HORNSEA OFFSHORE WIND FARM - PROJECT TWO APPLICATION

Planning Inspectorate Reference: EN010053

**WRITTEN SUBMISSION FOR DEADLINE 5**

Dated 12<sup>th</sup> November 2015

**Figure 1. Proportions of kittiwakes recorded at Potential Collision Height (PCH) (as % of all kittiwakes recorded at the site)**

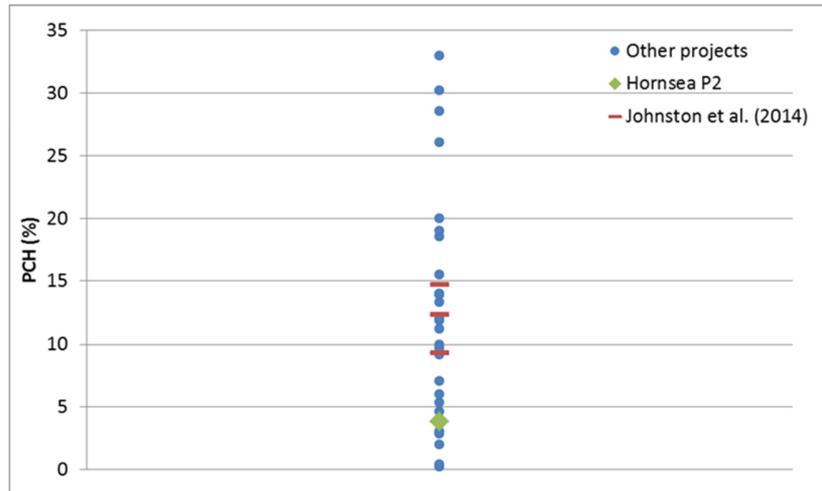
3.22 The current SNCB position on collision risk modelling for kittiwake is that it is only appropriate to use the Basic Band model collision outputs (JNCC et al. 2014). Within the Basic Band model there are two options which can be applied – Option 1 which requires a percentage of birds at collision height (PCH) derived from site specific data as a model input; and Option 2 which generates a PCH value for the specified project turbine height profile from a generic dataset of flight height data e.g. Johnston et al (2014) corrigendum.

3.23 Natural England's position on collision risk predictions for Hornsea Project 2 as set out at Deadline III is based on outputs from Option 2 of the Basic Band Model that use generic data on kittiwake flight behaviour rather than the site specific data from Hornsea P2. The reasons that Natural England has based its assessment on the Option 2 rather than Option 1 outputs are set out in our relevant representation (Appendix 1, paragraphs 24-30) and written representations (paragraph 6.5.34 – 6.5.37) and can be summarised as:

- Concerns about the accuracy of boat based observers at recording birds in flight to the nearest 5m height level;
- Concerns about the false precision resulting from assignment of birds in flight to height bands (0-2.5m, 2.5-7.5m, 7.5-12.5m, 12.5-17.5, 17.5-22.5, 22.5-27.5, 27.5-32.5 etc);
- Post collection processing of birds in flight data to calculate PCH values coincident with the rotor height (24.08m above mean sea level);
- Site specific PCH data for Hornsea P2 that are low compared to data collected at other offshore project areas, without any clear ecological explanation for differences, and which additionally fall outside the 95% CLs of the Johnston et al (2014) corrected generic data; and
- No consideration of variability and uncertainty in flight height data factored into subsequent collision risk modelling.

3.24 These concerns relate to the site specific data collected at Hornsea Project 2. As a result of our concerns about the site specific data, Natural England based its assessment of impacts on generic data on kittiwake flight heights that were generated by modelling flight height data across a range of offshore windfarm project areas. Natural England considers that this gives a better representation of likely kittiwake flight behaviour, and allows consideration of variability in flight heights in the collision risk modelling. This approach is consistent with Natural England's approach to other projects where there have been concerns about the accuracy of the site specific flight height data, for example at Dogger Bank Creyke Beck (A&B) and Dogger Bank Teesside (A&B) where Option 2 outputs were used due to methodological issues with the flight height data and concerns about whether the PCH data were representative of bird behaviour at the site. In the case of Dogger Bank the PCH value was 20% and fell above the CLs of the generic data.
